Planning Application 3/2022/0804

Representations on proposed development:

drawing no	002
scale	1:200 at A4
date	August 2022
drawn	DC

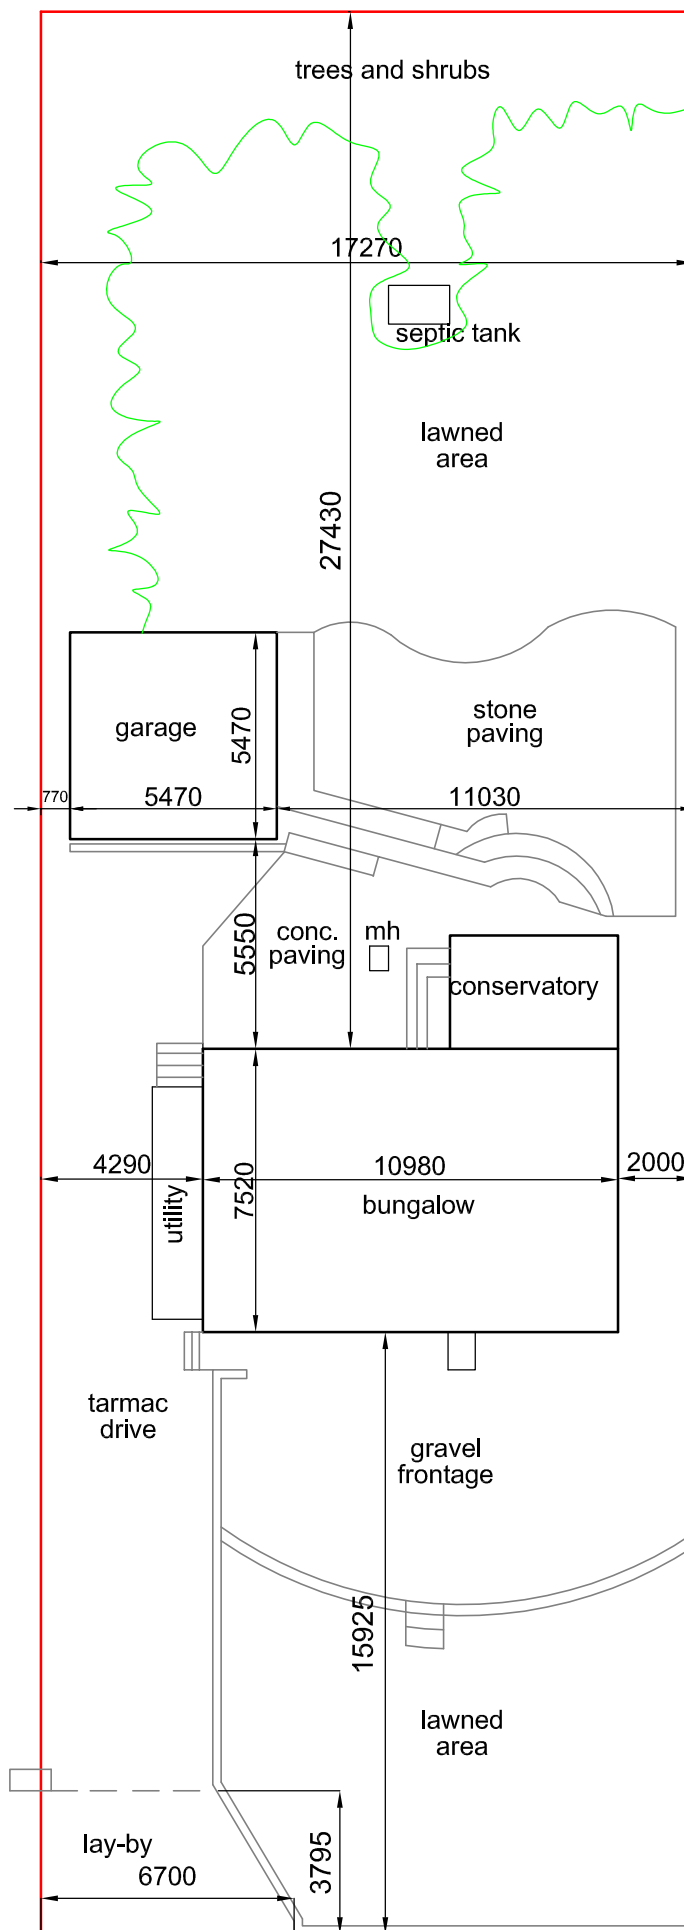
The increase in overall footprint of the property, along with additional car parking could result in additional surface water due to the lack of natural drainage. The proposed site plan identifies lawn, trees and shrubs to the rear of the property. It further states that no trees needed removing. This has not been complied with, and in excess of 50 square metres of established trees and shrubs have already been removed and replaced with artificial grass and a 3 metre high fence. This adds further concern to the issue of drainage, its impact on surrounding properties, and the destruction of the natural habitat of wildlife.

It is unclear how access is gained to the septic tank that serves a number of properties when the driveway access is replaced by the side extension.

drawing no 006
scale 1:100 at A3
date August 2022
drawn DC

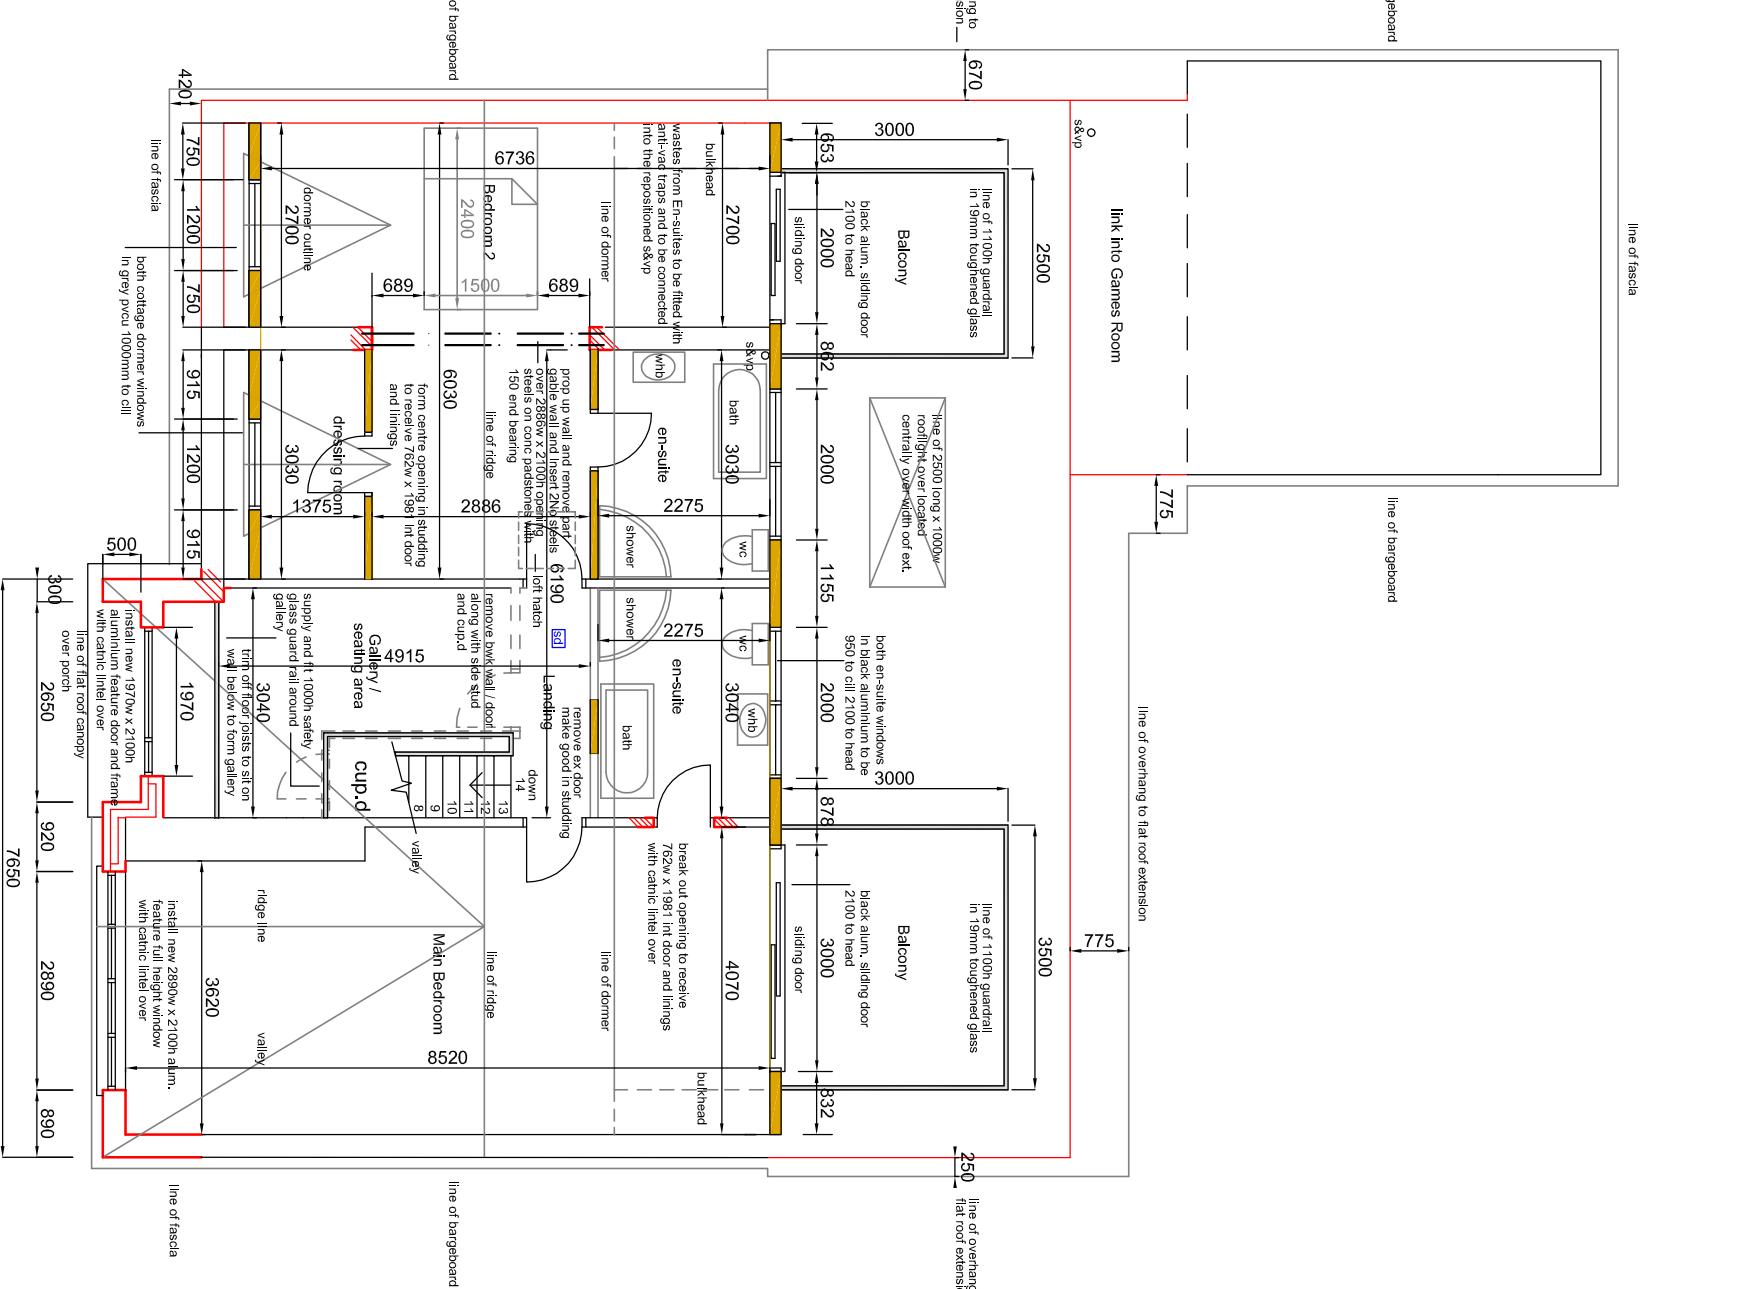
The two-storey side extension would be less than [REDACTED] The ground floor wrap round extension linking into the existing garage (and proposed change of use) results in a games area and bar [REDACTED] The wrap round flat roof to the rear extension will further extend to create a ground floor link to the newly designated games area that results in a wall of over 3 metres in height and [REDACTED]

A proposed balcony on the flat roof wrap round to the rear extension would be only [REDACTED]

The proximity and size of the proposed wrap round extension, link and change of use of the [REDACTED]
